Consultation Response from KC Landscape	
Application No:	2023/93350
Proposed Development:	Development of former Deighton Centre (previously Deighton High School) comprising Social Emotional and Mental Health School (use class F1) comprising single and two storey educational buildings; roof mounted photo-voltaic panels; sensory garden spaces; multi-use games areas; landscaping; hardstanding areas; carparking; access with secure fencing and ancillary development
Location:	former Deighton Centre, Deighton Road, Deighton, Huddersfield, HD2 1JP
Applicant/Agent:	Lichfields
Planning Officer	Ellie Thornhill
Date Responded:	08.01.2024
Responding Officer:	EM
Responding Ref:	MM108

**Joseph Norton
Academy
Deighton //**
Landscape Statement

ECOLOGICAL MITIGATION STRATEGY

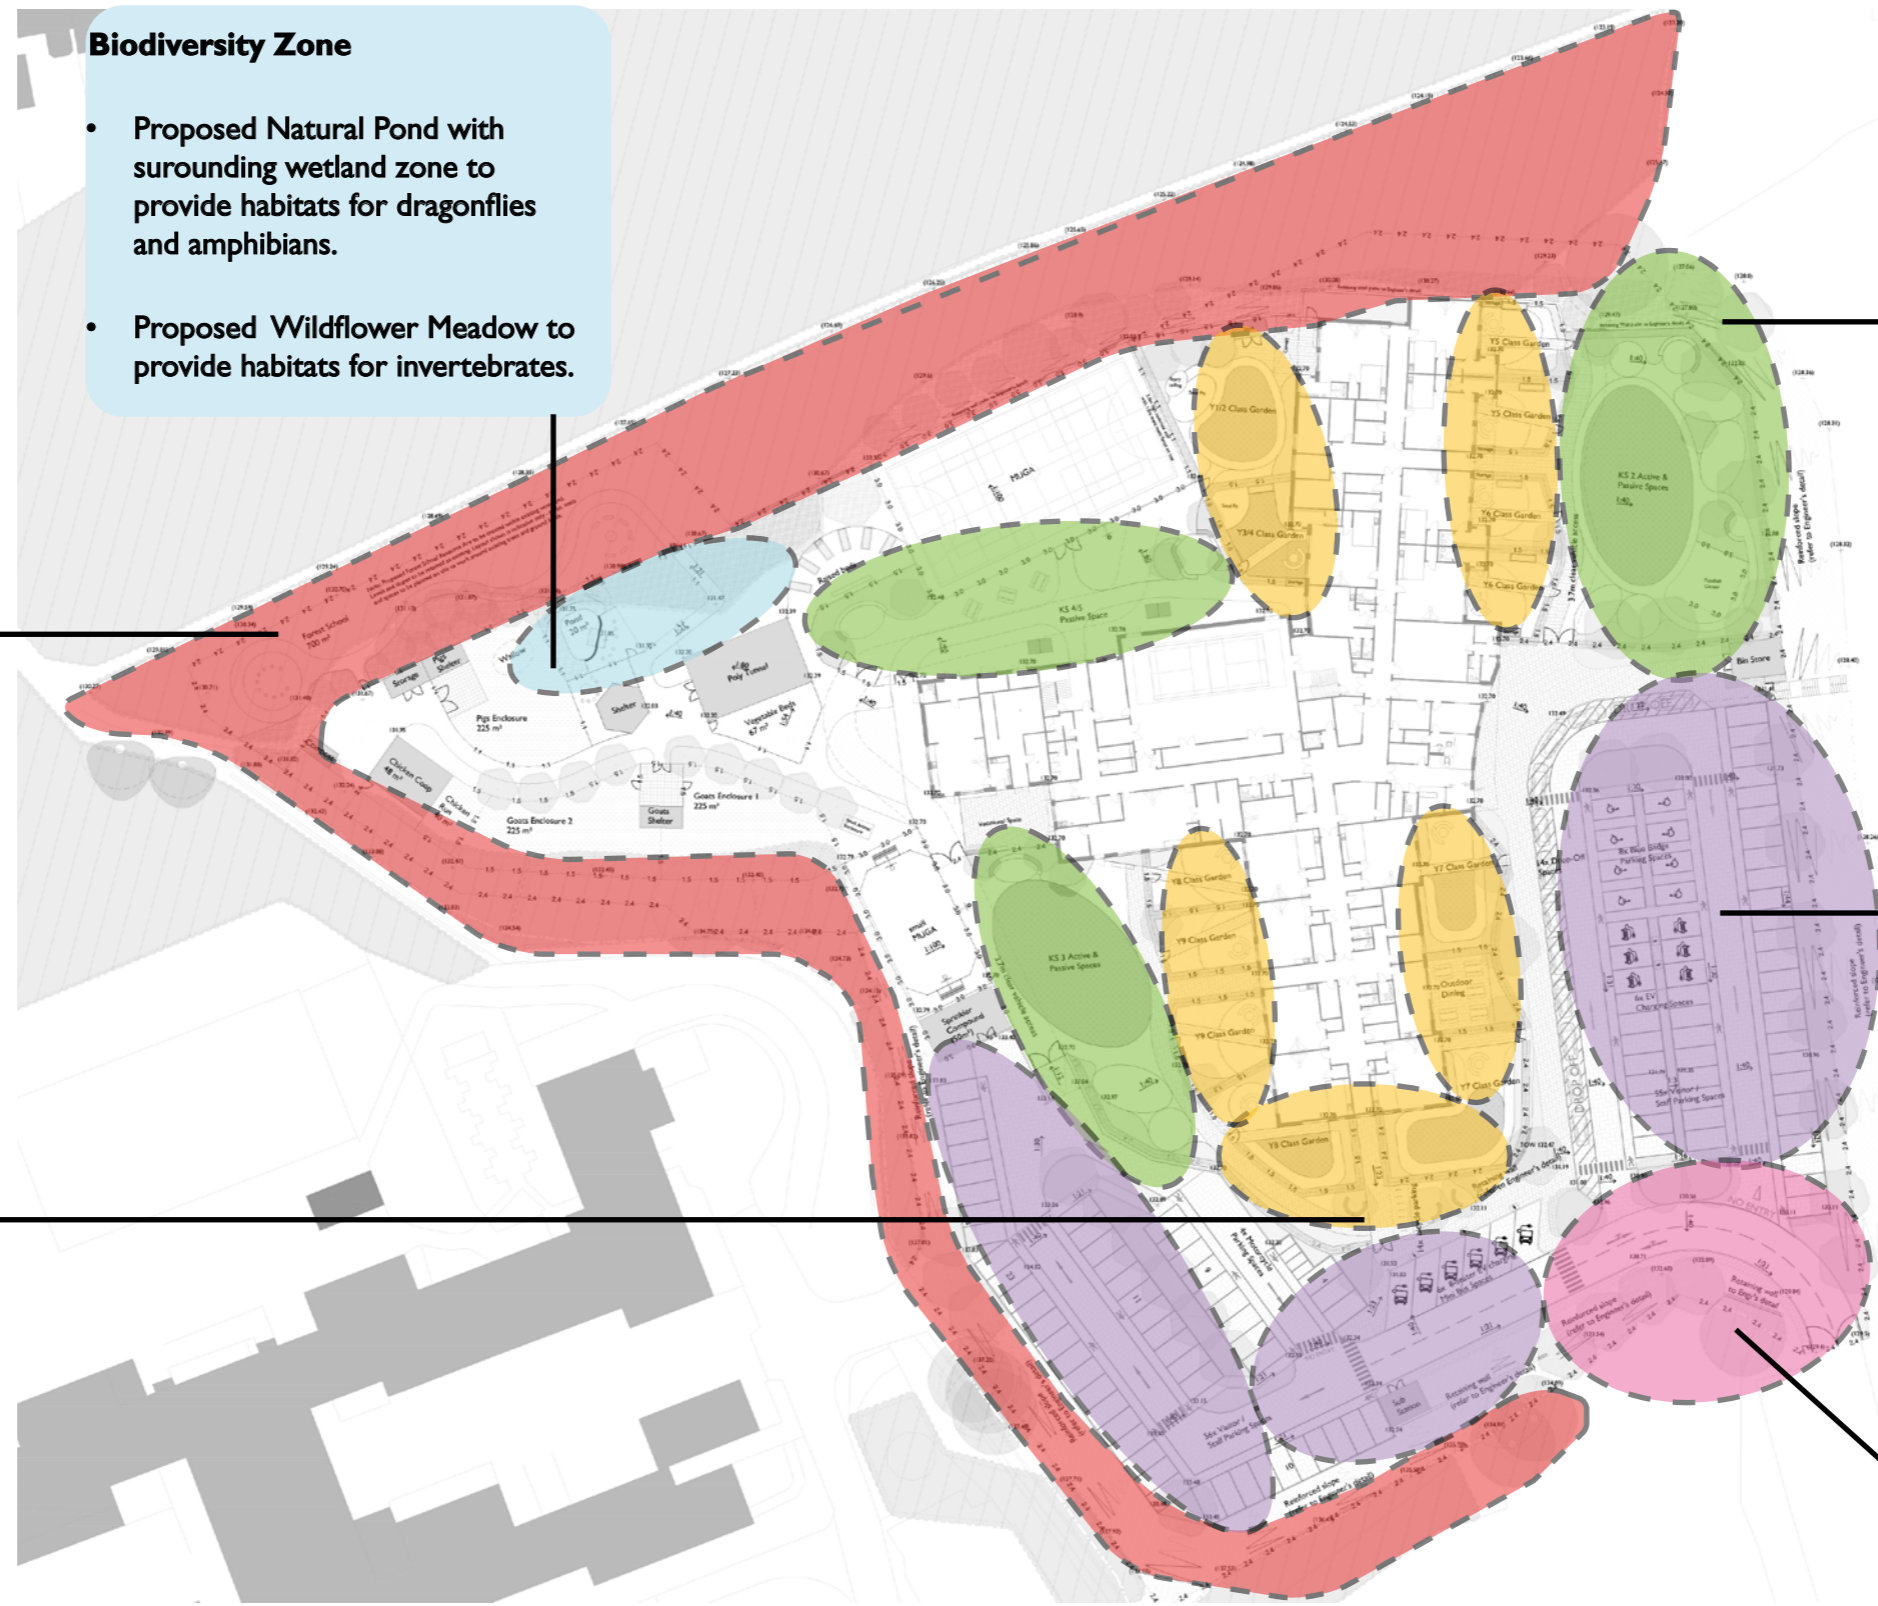
Layout of class gardens is not a detail layout with obvious shortcomings so these indicative designs are not satisfactory and cannot be approved. e.g. the size of telling is very small next to a distracting sand space? The quality of materials needs to be clarified. Sand areas are shown immediately next to hedge with potential issues. No methodology of retention of the sand facility is explained. Overall the quality specification of these spaces needs better definition and it is recommended that the specification information is increased in detail to explain level of quality and quantity with associated rational/purpose. In addition approval of detail layout and final materials choice is a reserved matter.

Use of wetpour does not have clear rational unless fall equipment is likely to be part of these spaces. Expensive to manage maintain and ultimately dispose of.

Seating design appears to take no account of age of students, numbers, needs for intimate spaces and unclear how the adult student ratios expected in these spaces are expected to be accommodated.

The shape of some of the class gardens are oversized for the stated aims and go around corners which is normally to be avoided in any school context.

The space of the areas do not create the intimate areas described as being a purpose.

KS4+5 ACTIVE / PASSIVE SPACES (years 7, 8, 9)

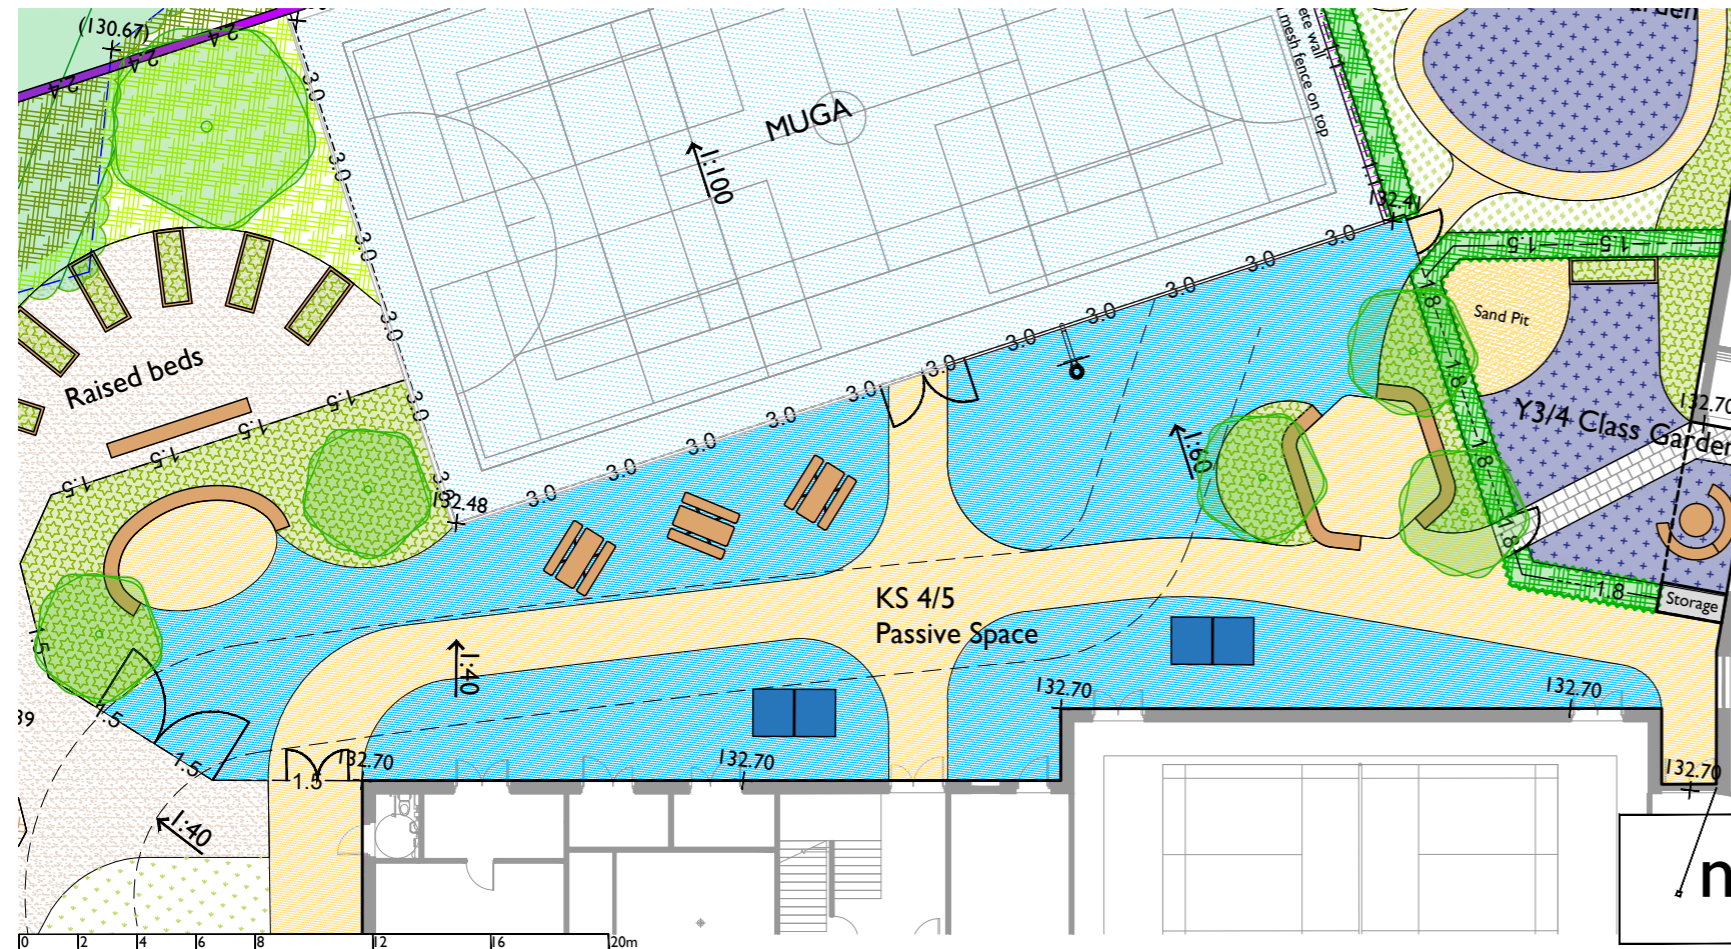
There is no indication that the equipment described alongside other activities described fits in the space. A detailed layout including equipment and fall zones etc with a commitment to a quality level needs to be supplied.

BOUNDARY TREATMENTS

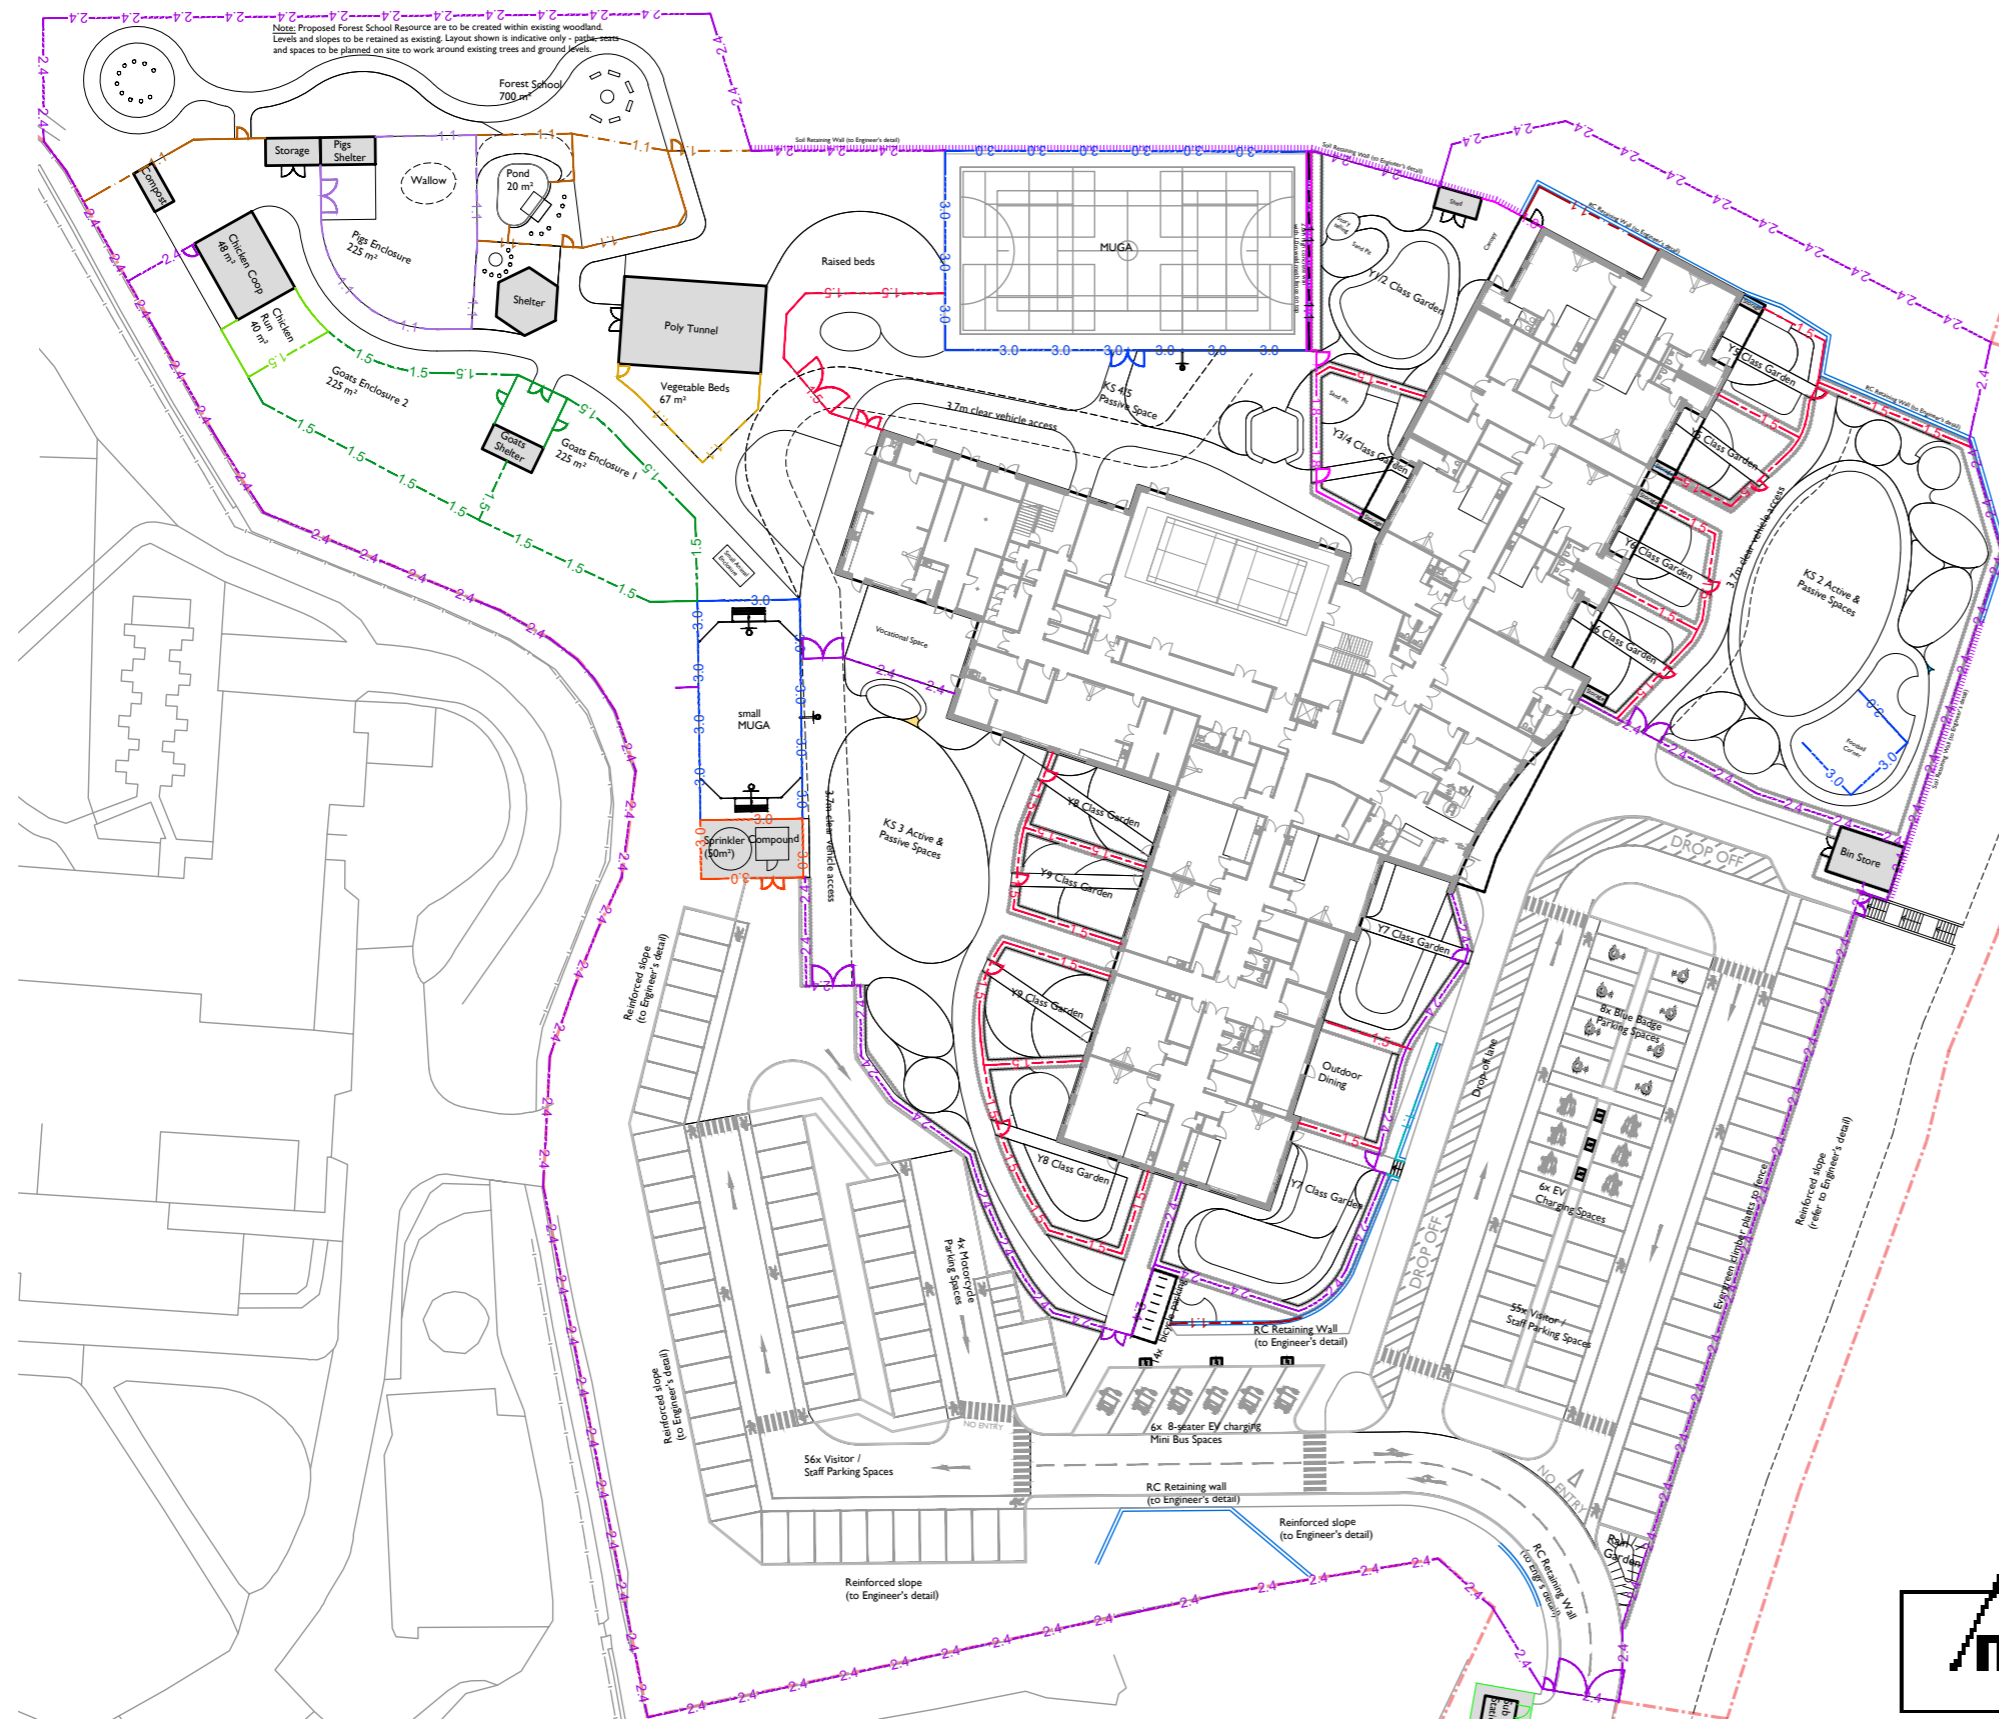
- 1.5m Anti-climb Weld Mesh Fencing
- 1.8m Anti-climb Weld Mesh Fencing
- 2.4m Anti-climb Weld Mesh Fencing

MUGA fencing shown is not heavy duty - check if this is the appropriate standard for the school.

3.0m Rebound Weld Mesh Fencing to MUGA

Fencing: Unclear how the fencing panel choice will work where there are major slopes and changes in level. Is 2.4m the max height dropping to lower where there is staggered panels or is 2.4m the minimum height with taller panels needed to deal with the level changes and retain this minimum to keep the site secure? Clarity is required to confirm which this is.
